CITY OF PORTLAND

BUILDING PERMIT

Job ID: 2011-03-616-ADDR

has permission to Extend existing deck 7' x 45"

OVER HEAD
VIEW

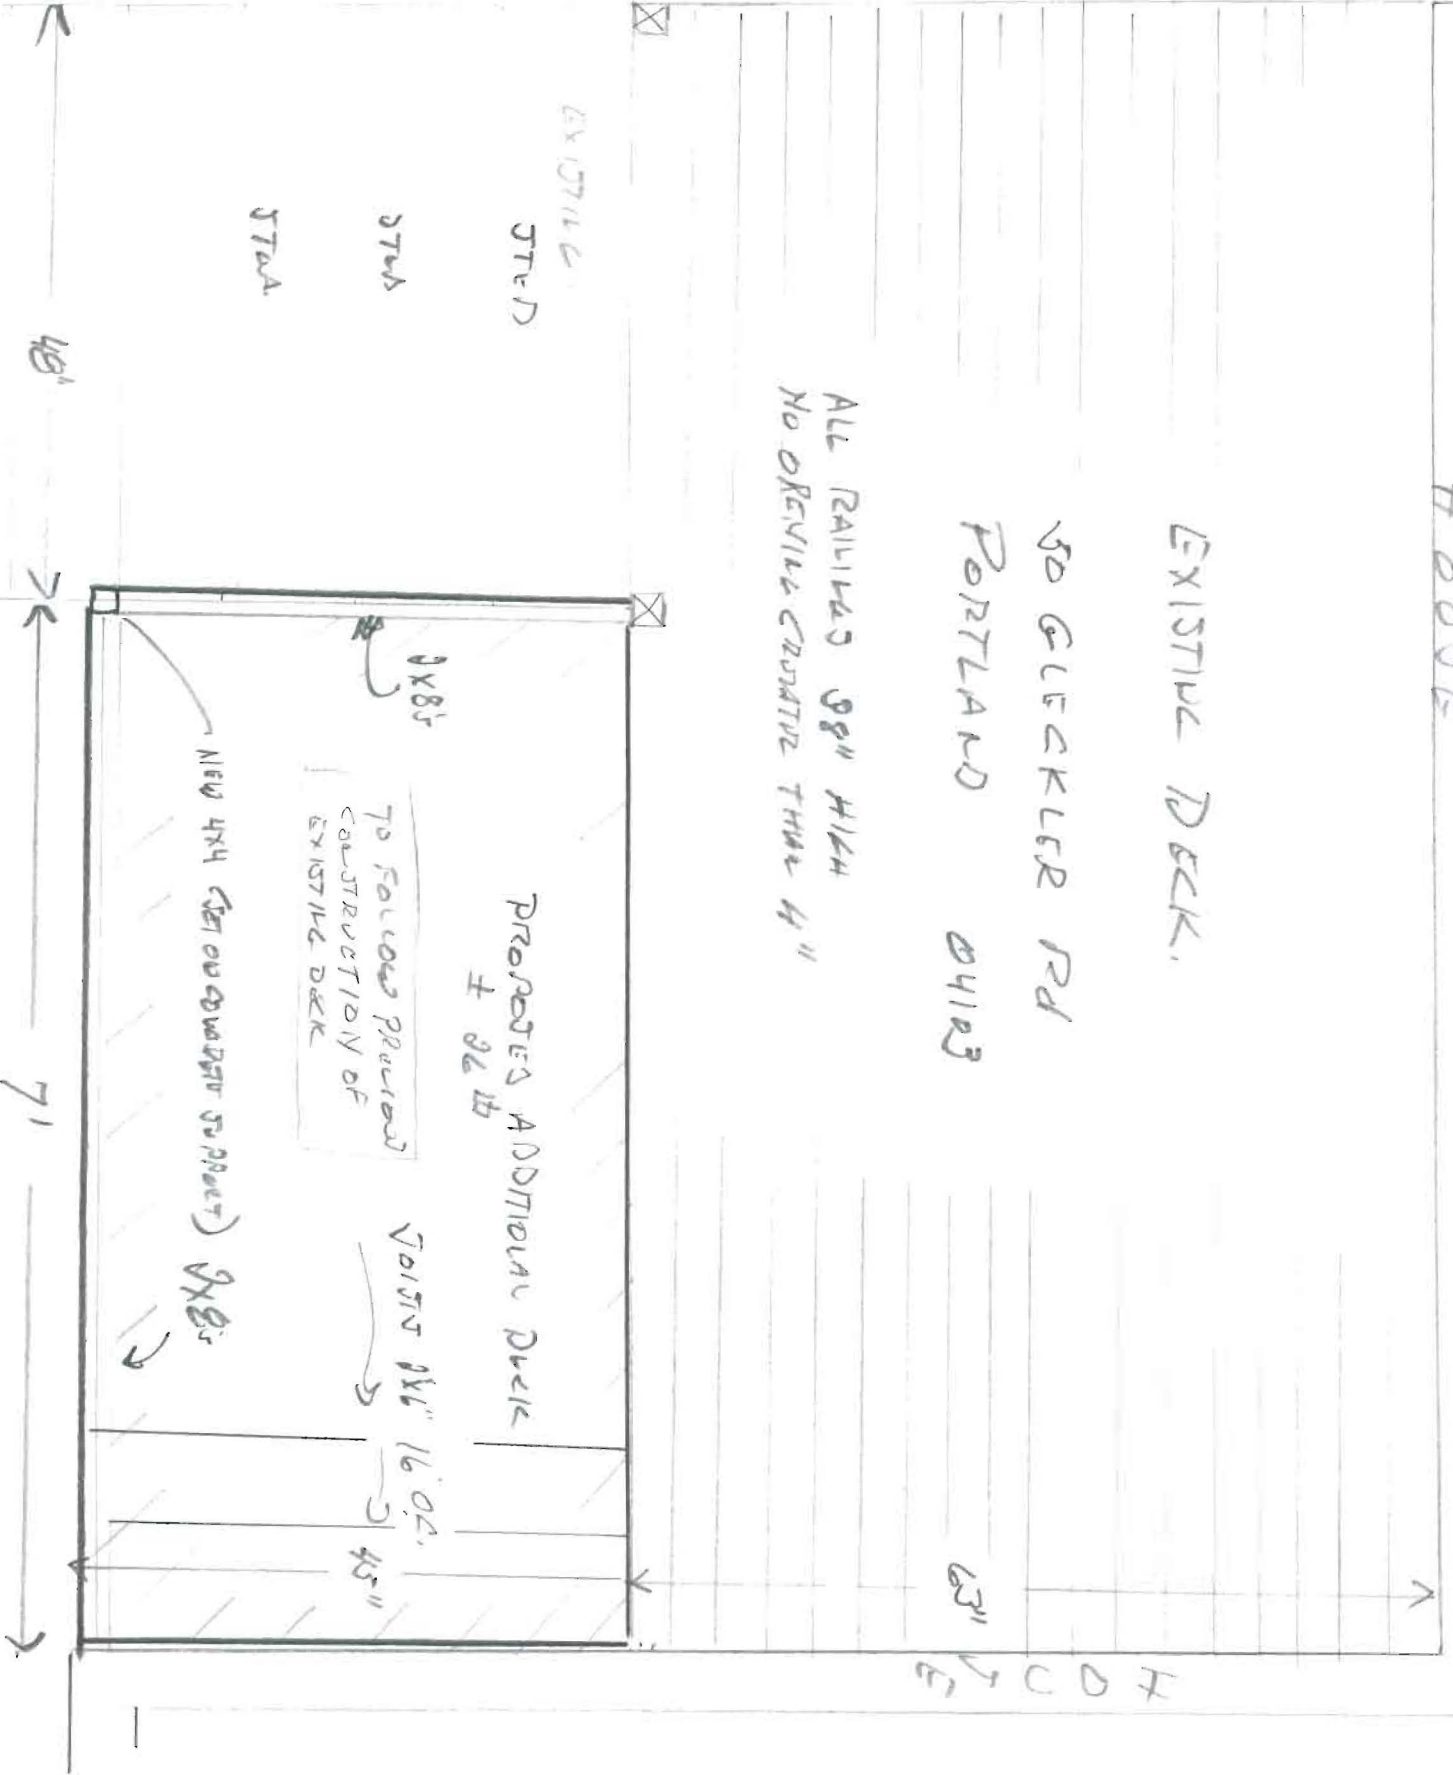
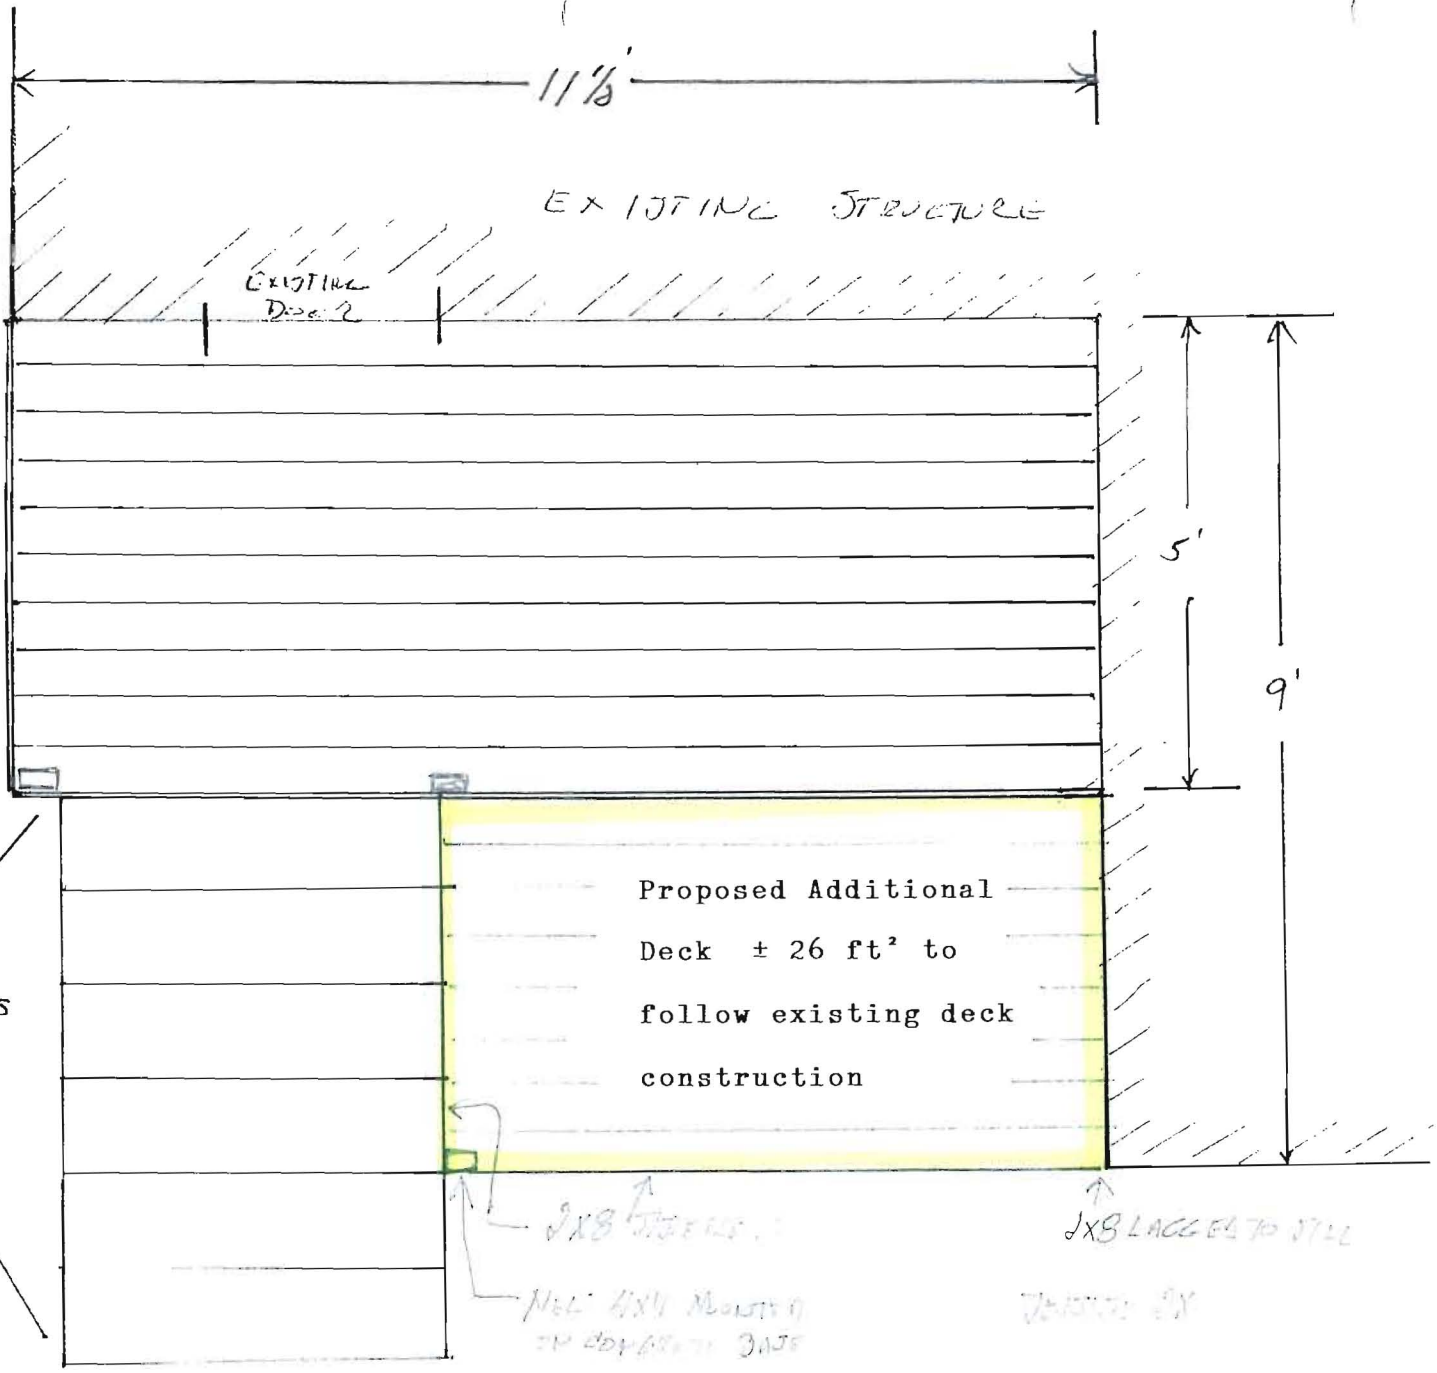
1. Provide double 2x8 girders.
2. Provide positive bearing at girder/post connection.
3. Provide "Deck lateral load connection" in conformance with IRC 502.2.2.3
4. Separate permits are required for any electrical, plumbing, sprinkler, fire alarm HVAC systems, heating appliances, commercial hood exhaust systems and fuel tanks. Separate plans may need to be submitted for approval as a part of this process.
